Subject: SSD-59-Mod-5
Modification 5 Mannering Coal (MOD 5)
LAKE MACQUARIE NSW

Lake Macquarie City Council provides the following correspondence in response to the Department of Planning's request for advice (dated 17 June 2019) in relation to the above application.

Table 3: Maximum predicted 24-hour average PM<sub>10</sub> concentrations due to Project alone and corresponding background concentrations on the same date

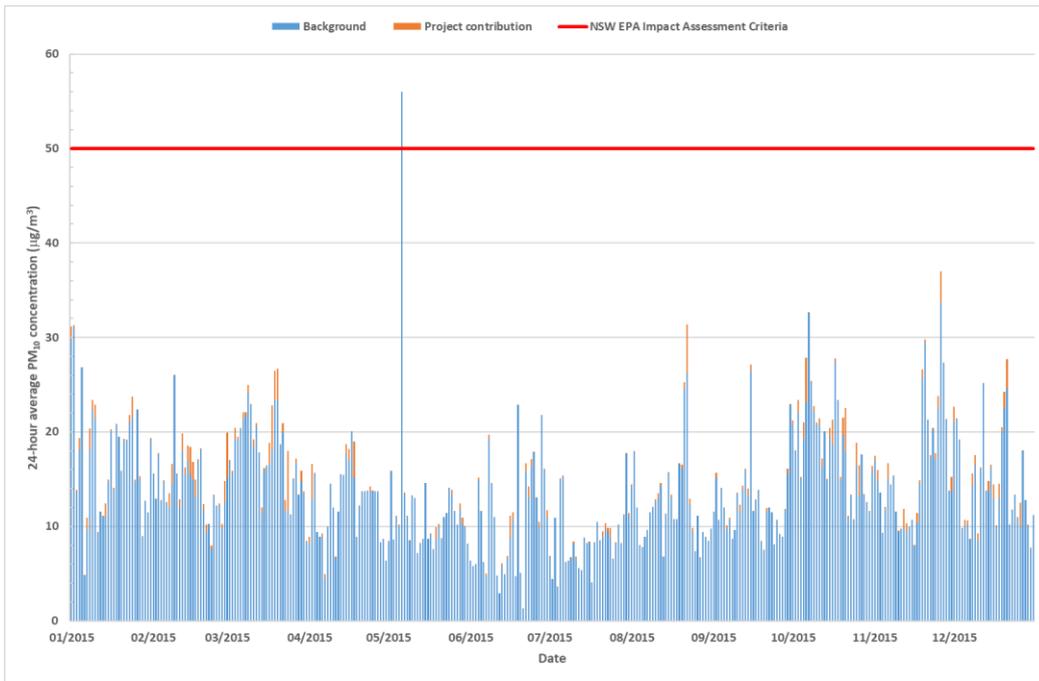
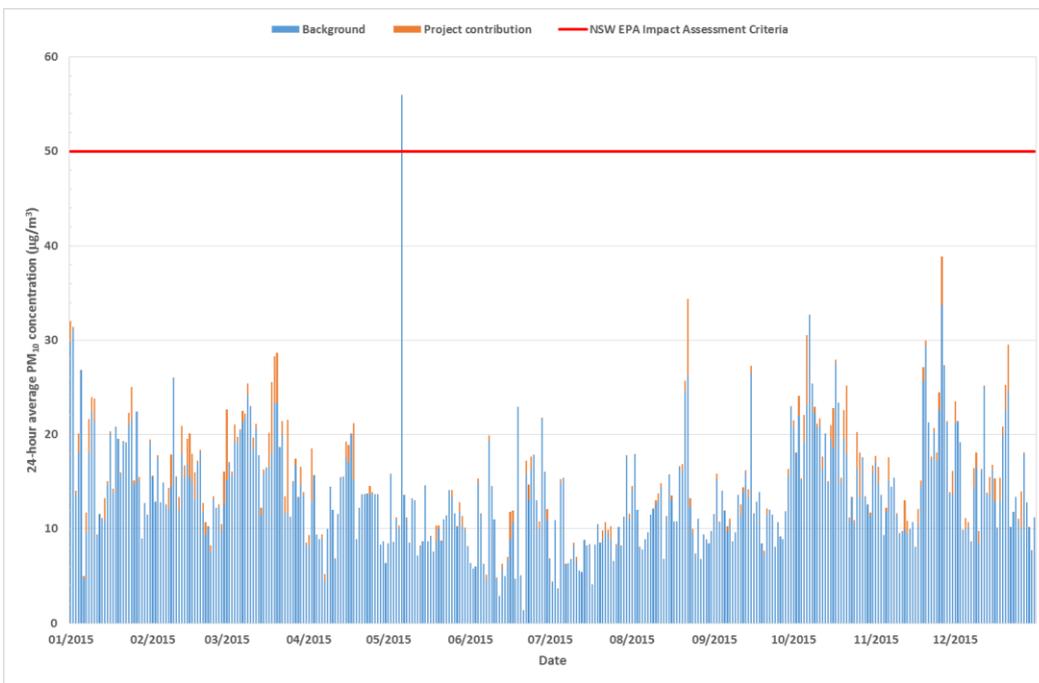
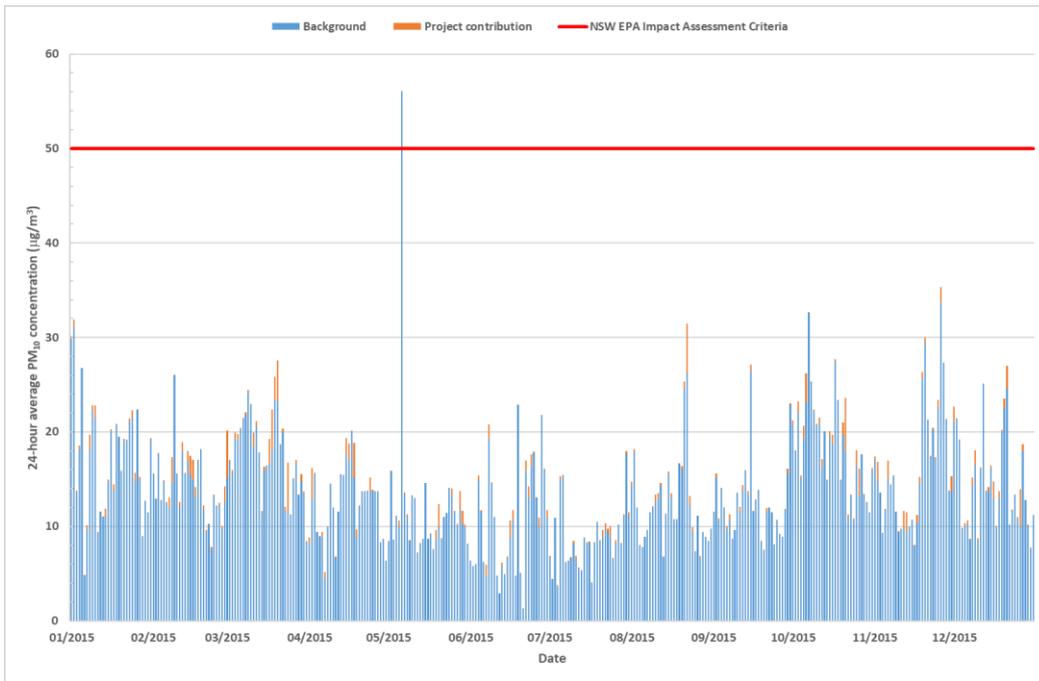
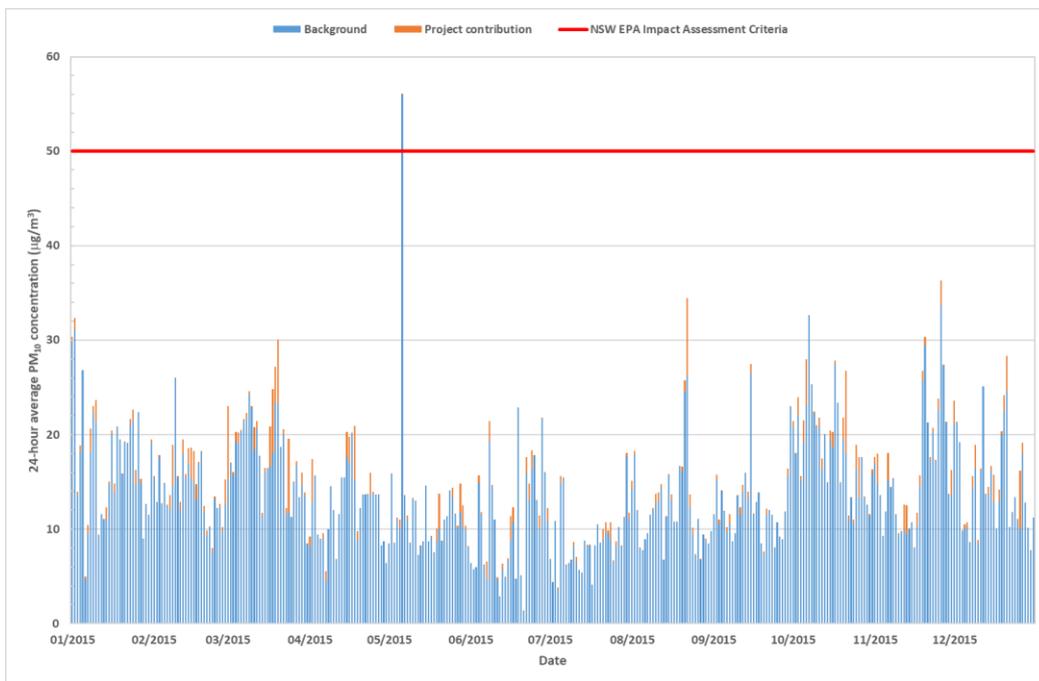
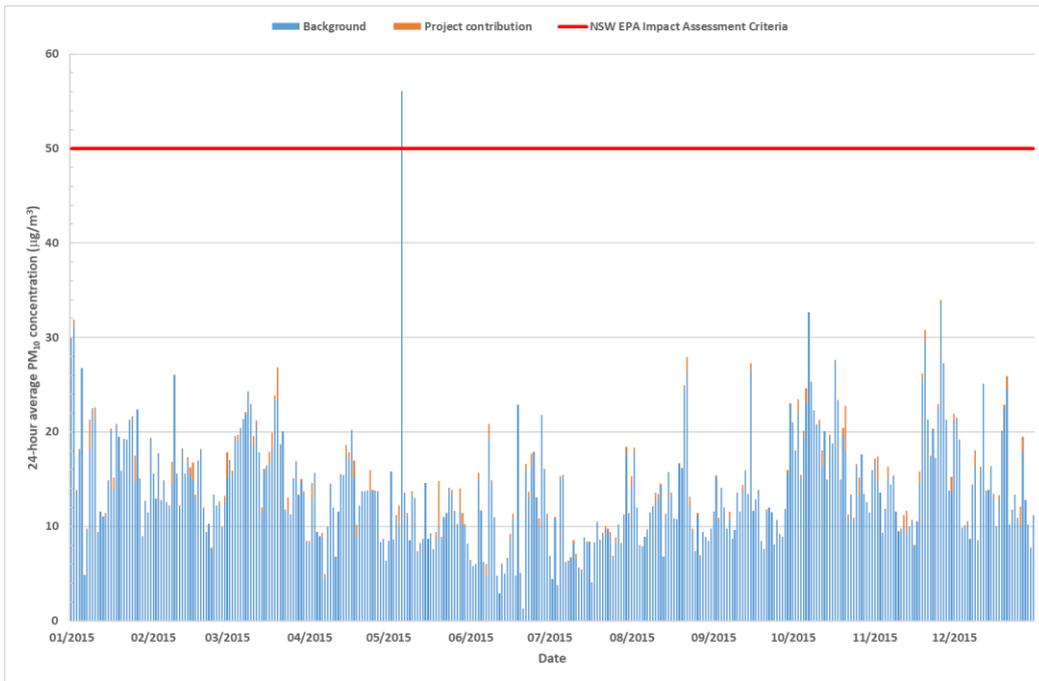
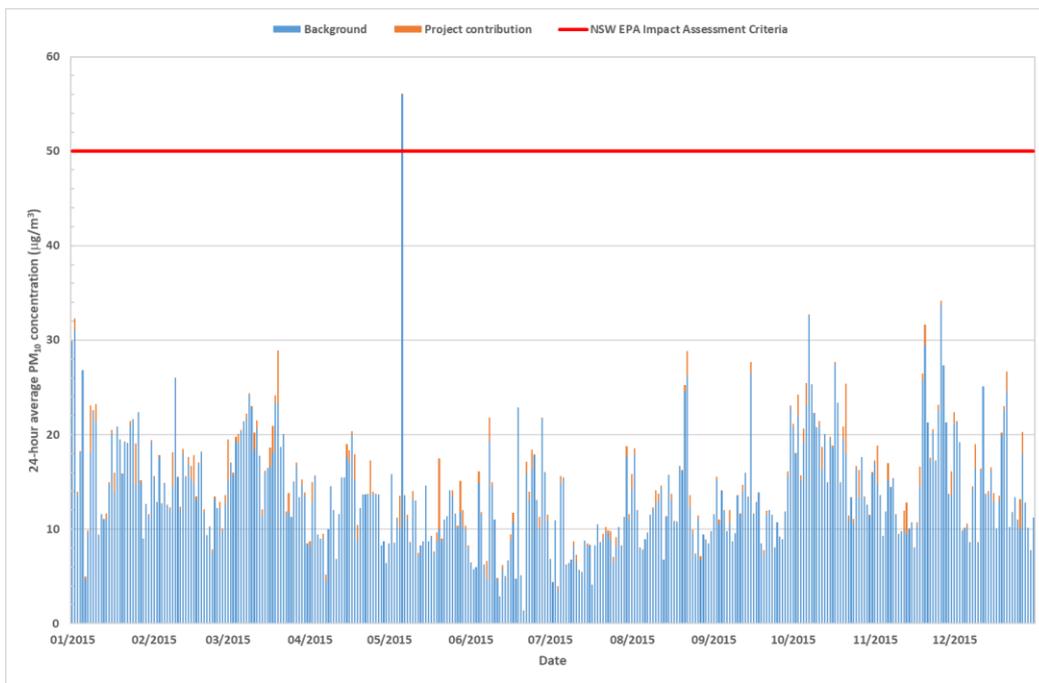
Council seeks clarity on Table 8.5, which predicts an increase in the 24-hour average PM₁₀ concentrations, but no increase in the “project plus background” value. It is noted that both the existing and proposed values appear to exceed the “Assessment criteria” figure.
